# Medworth Energy from Waste Combined Heat and Power Facility

PINS ref. EN010110  
Document Reference Vol.14.4a  
Revision: 1.0  
Deadline: 5  
June 2023

## **Applicant's comments on the Deadline 4 Submissions: Part 1 Statutory Parties**

**MEDWORTH ENERGY FROM WASTE COMBINED HEAT AND POWER FACILITY**

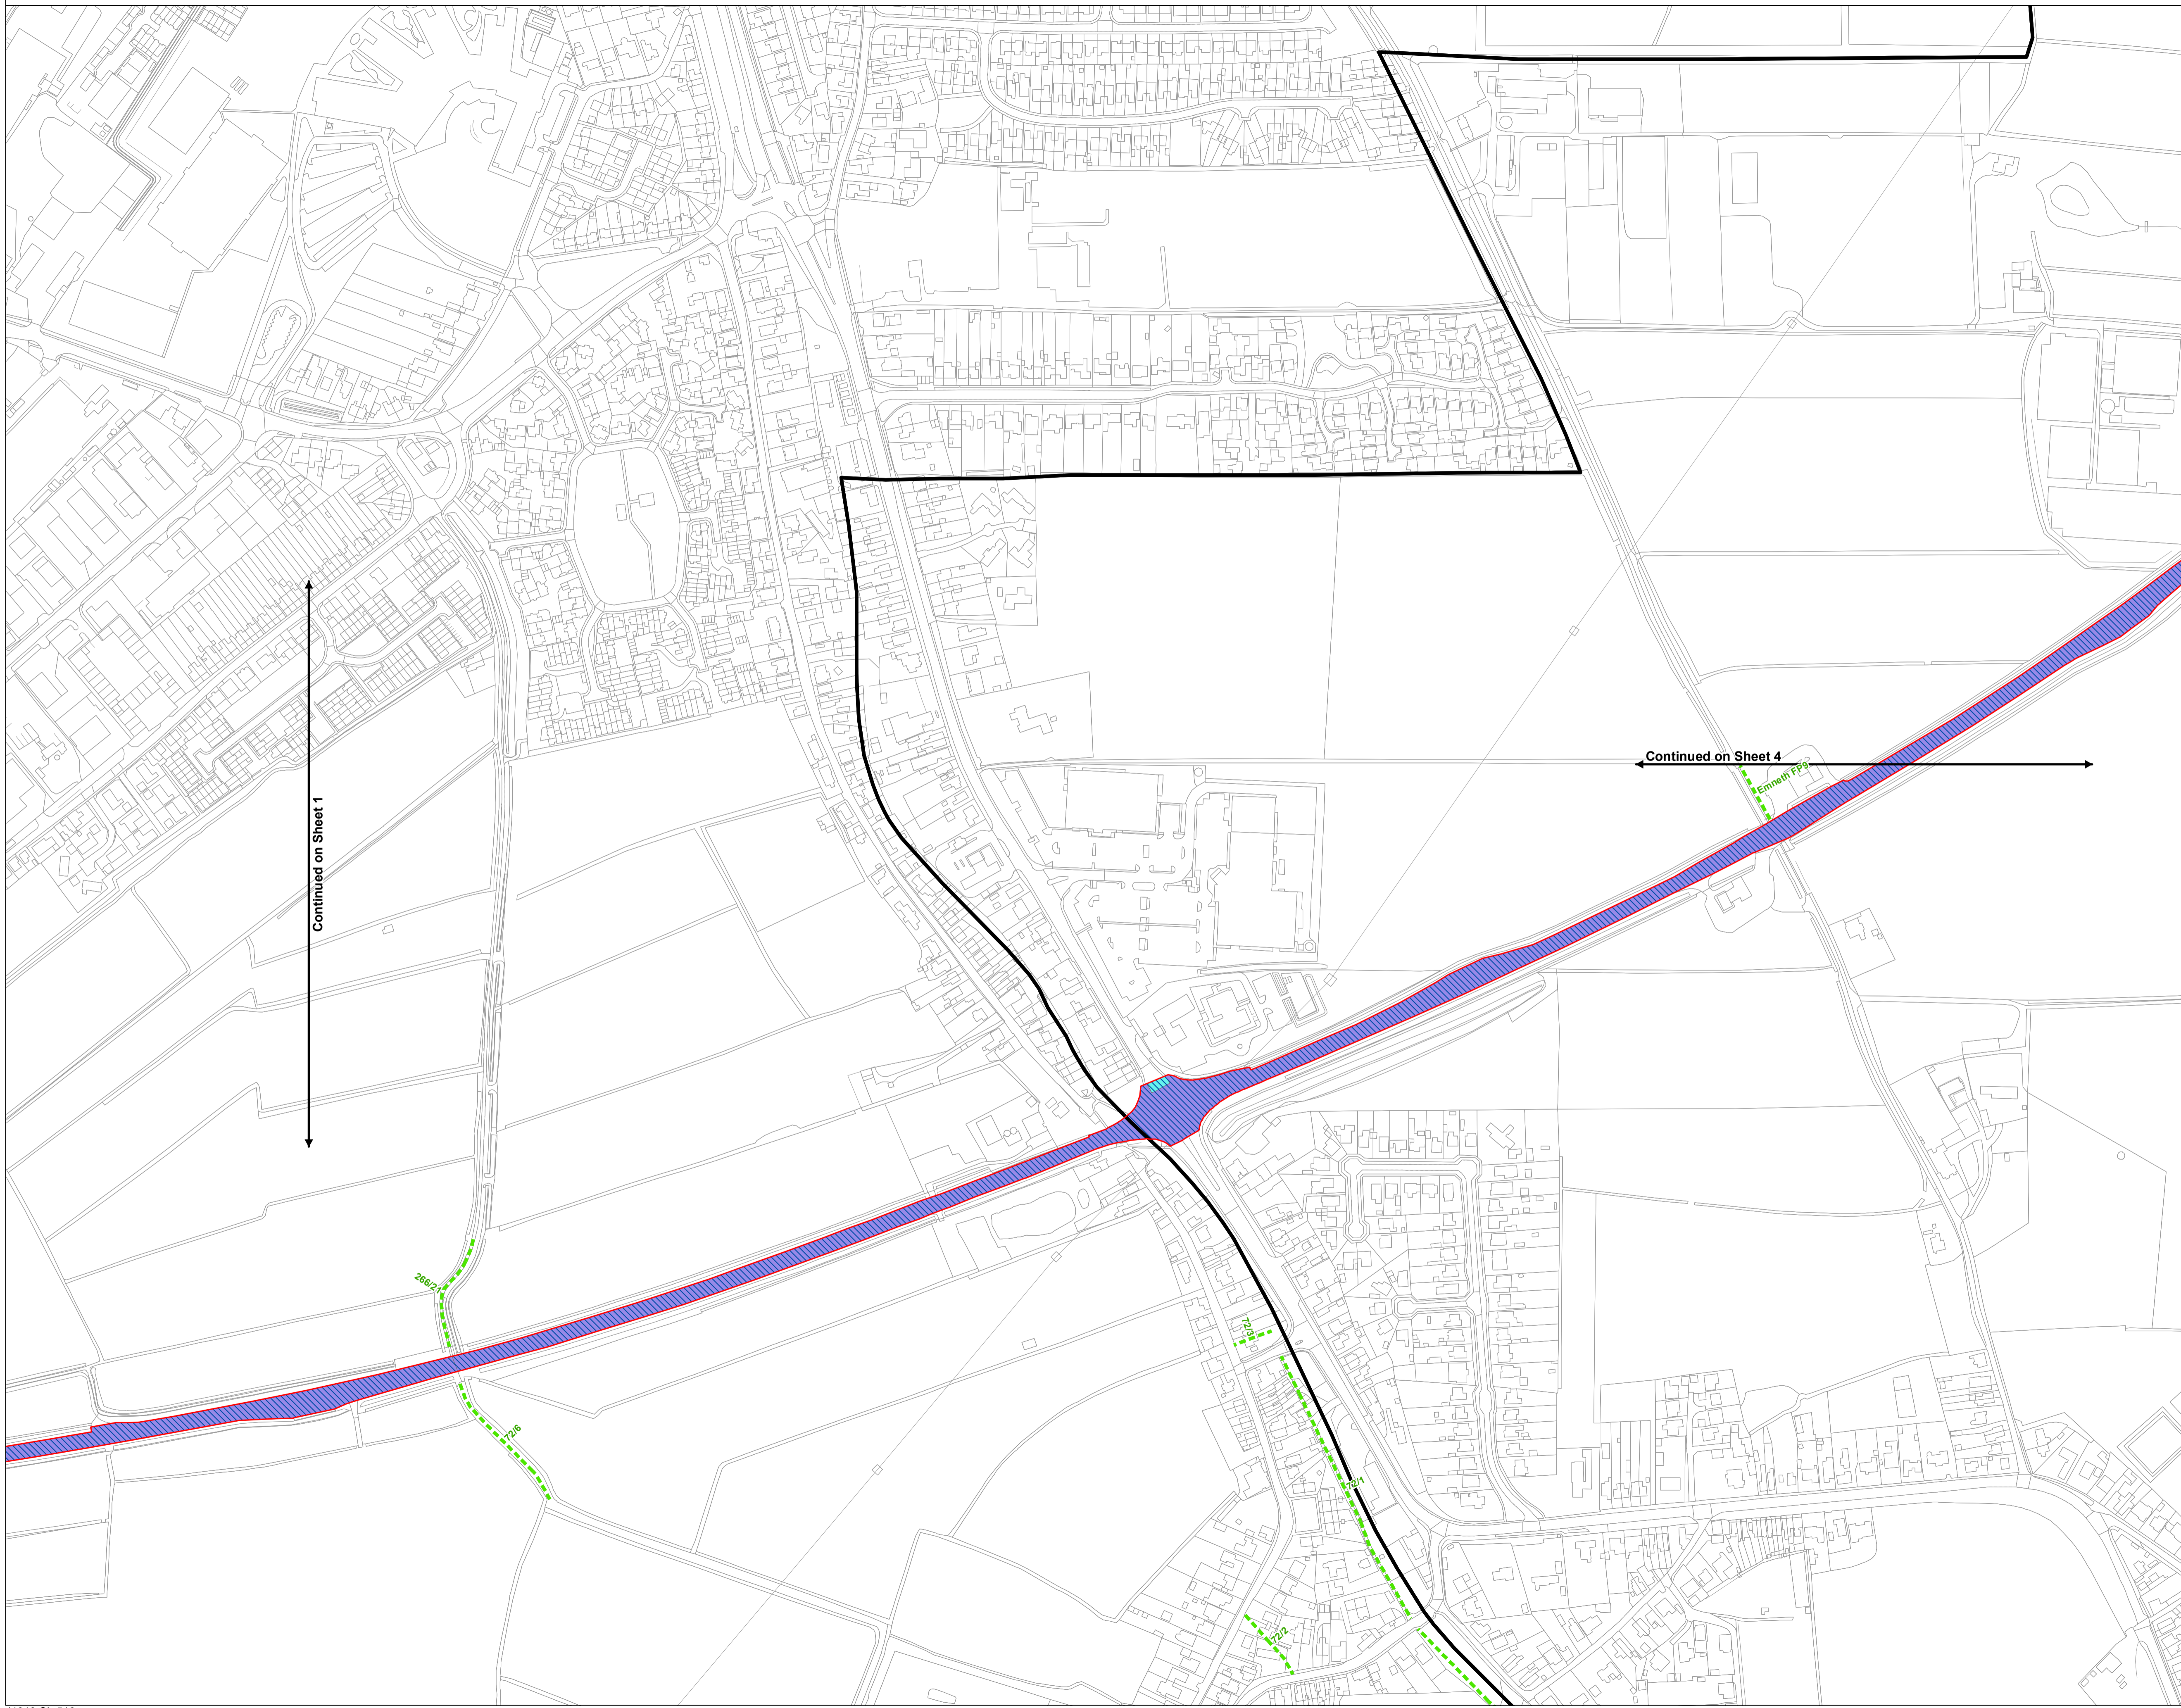
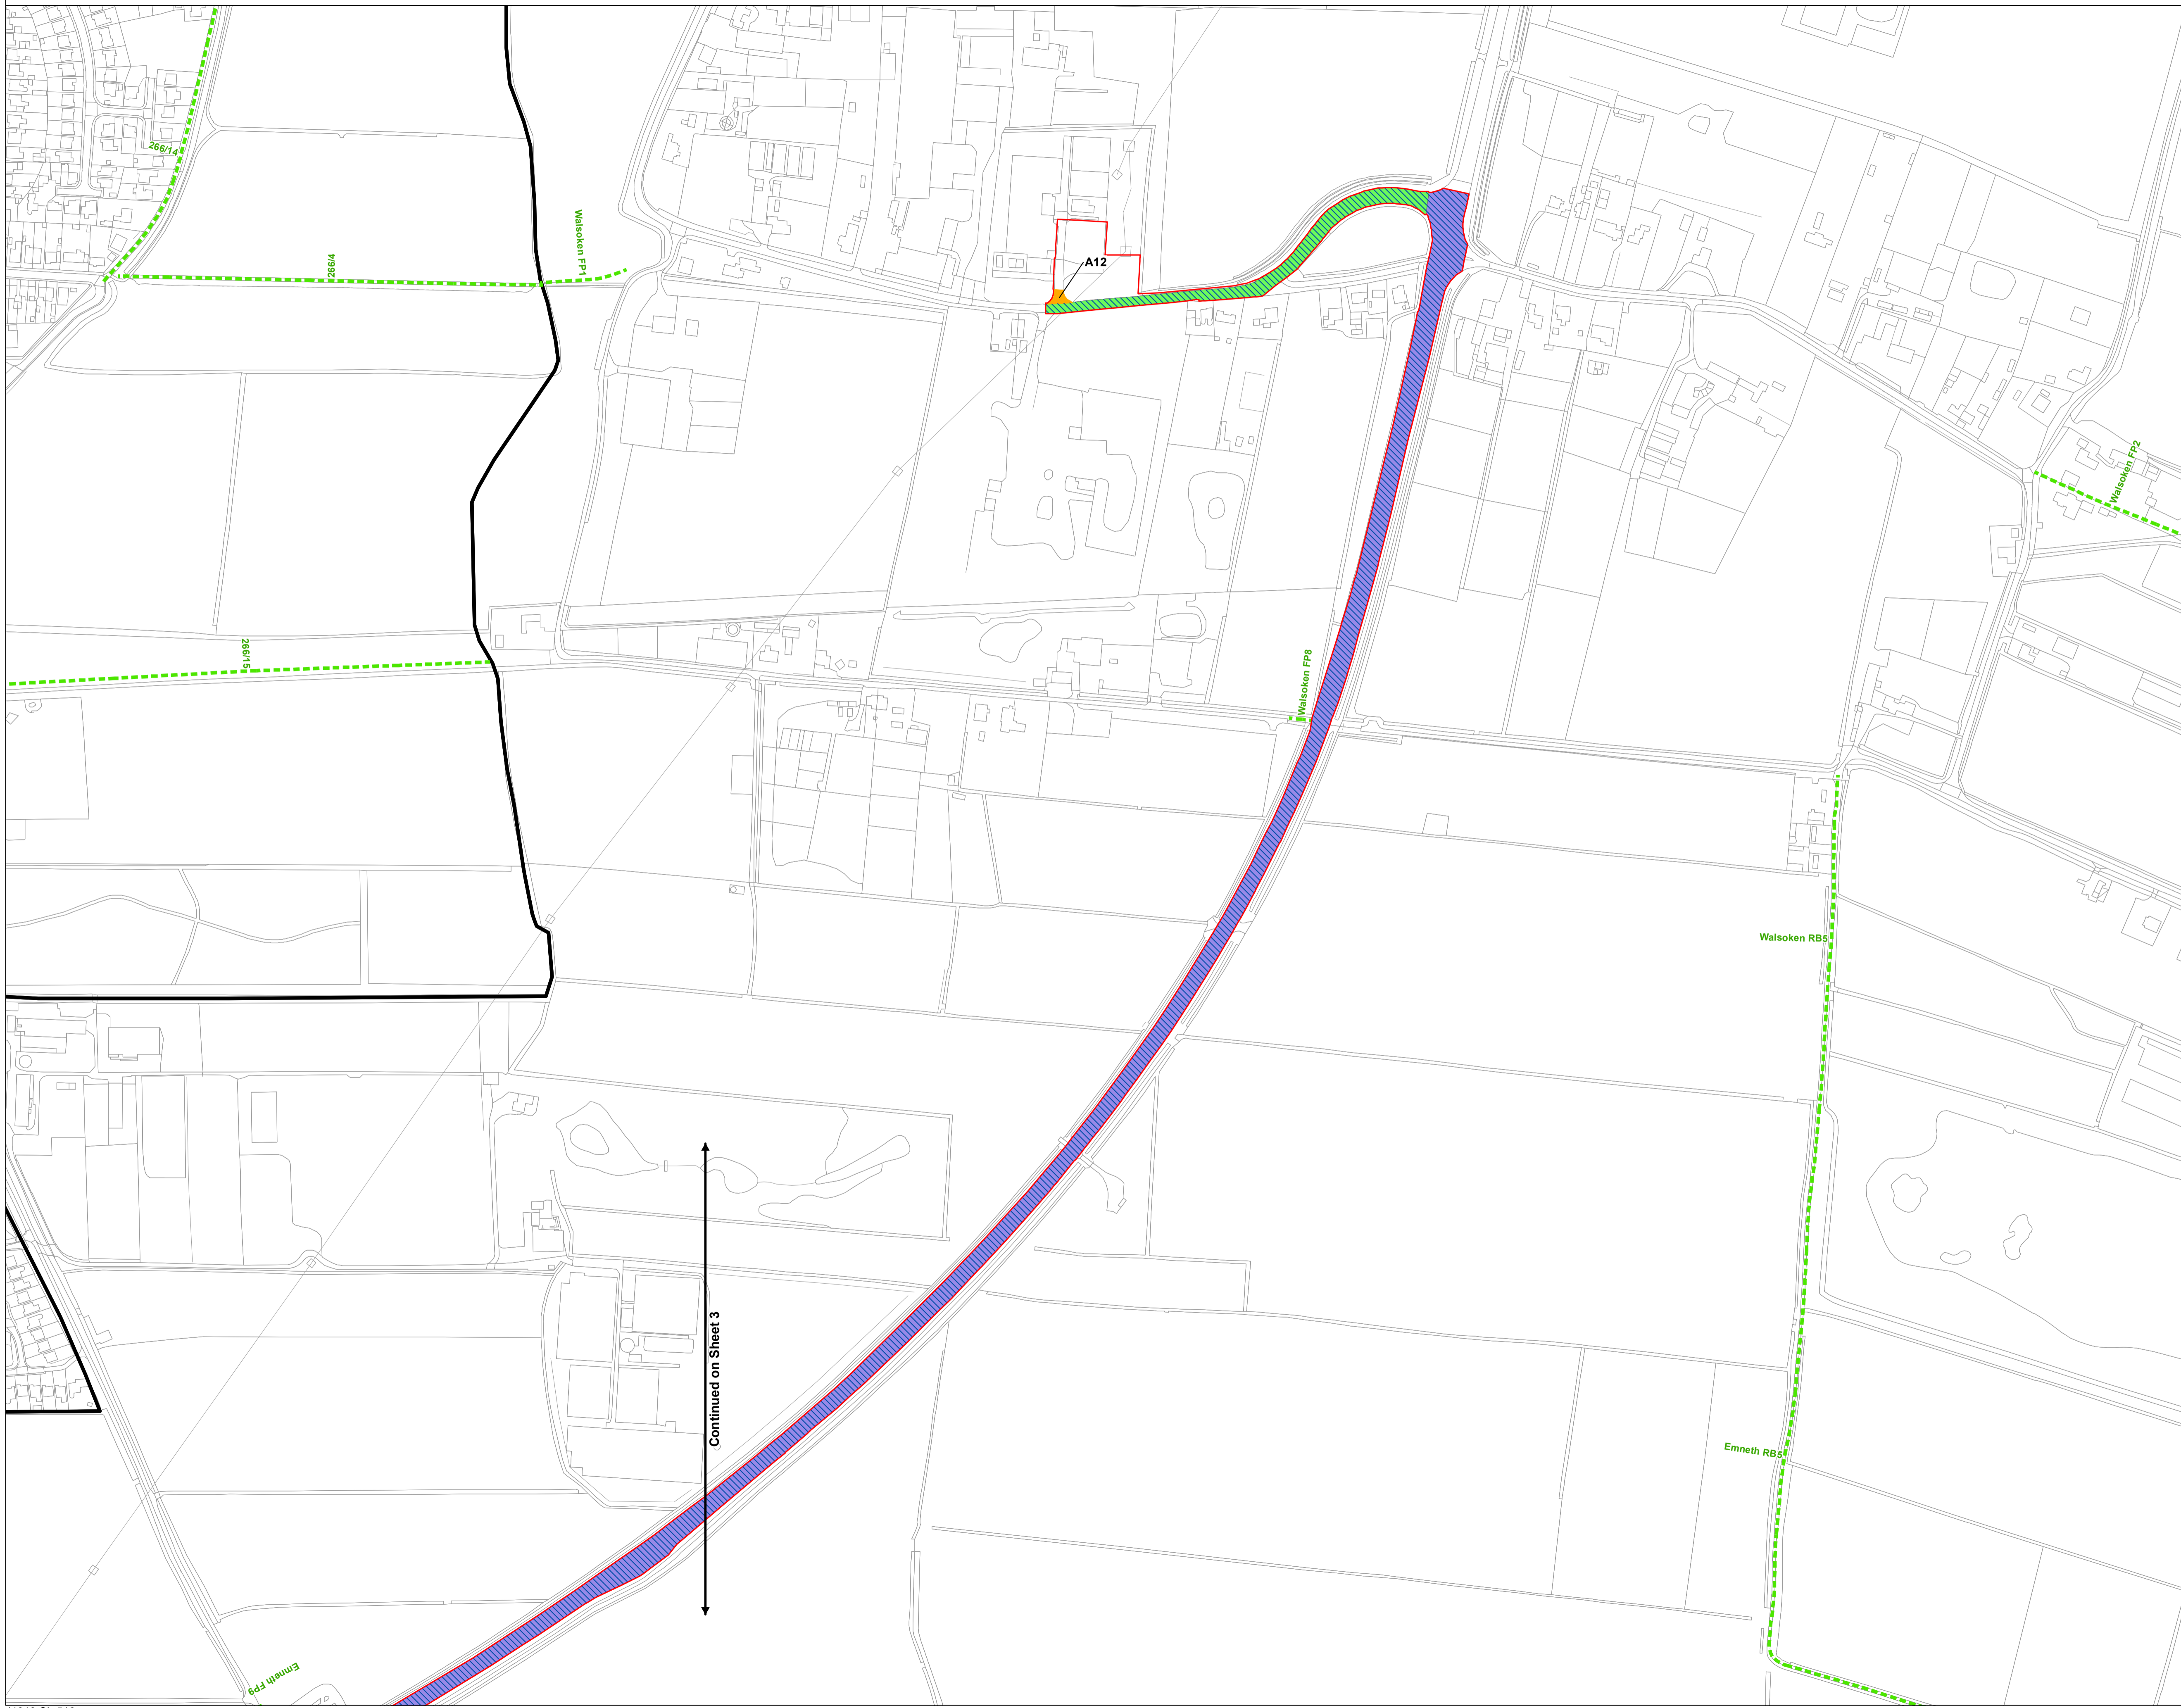
<b>2.4 ACCESS AND RIGHTS OF WAY PLAN (REV 4) [REP3-005]</b>		
Highway boundary – amendment to order limits	CCC was made aware on 16 May 2023 that the Applicant intends to make a request for nonmaterial changes to the Application for Development	Comment noted. Revision 4A of the Access and Rights of Way Plan, showing the proposed change to the Order Limits and access, was submitted to the ExA on 5 June 2023 [AS-021]. As

Topic/Para	Representation	Applicant Comment
	<p>Consent, in order to change the Order Limits at the junctions of New Bridge Lane with (respectively) Cromwell Road and Salters Way. CCC is in discussions with the Applicant about this matter and is considering the impact Page 2 of 19 that changing the Order Limits would have in relation to the extent of the affected highways. The highway boundaries in this location are currently being considered and CCC will continue to engage with the Applicant in respect of this matter.</p>	<p>noted above, the Applicant can confirm that negotiations with CCC are ongoing. The Applicant's change request [AS-028] specifically addressed the point relating to the extent of the highway maintainable at public expense.</p>
Highway boundary – Sheet 2	<p>The highway boundary within the Order Limits on Weasenham Lane is not shown correctly in the vicinity of accesses A1 and A2. The Applicant has been engaging with CCC on this matter and it is anticipated that future iterations of the Plans will be corrected.</p>	<p>The Applicant has engaged with CCC and updated the plan accordingly. The revised plan is submitted at Deadline 5.</p>
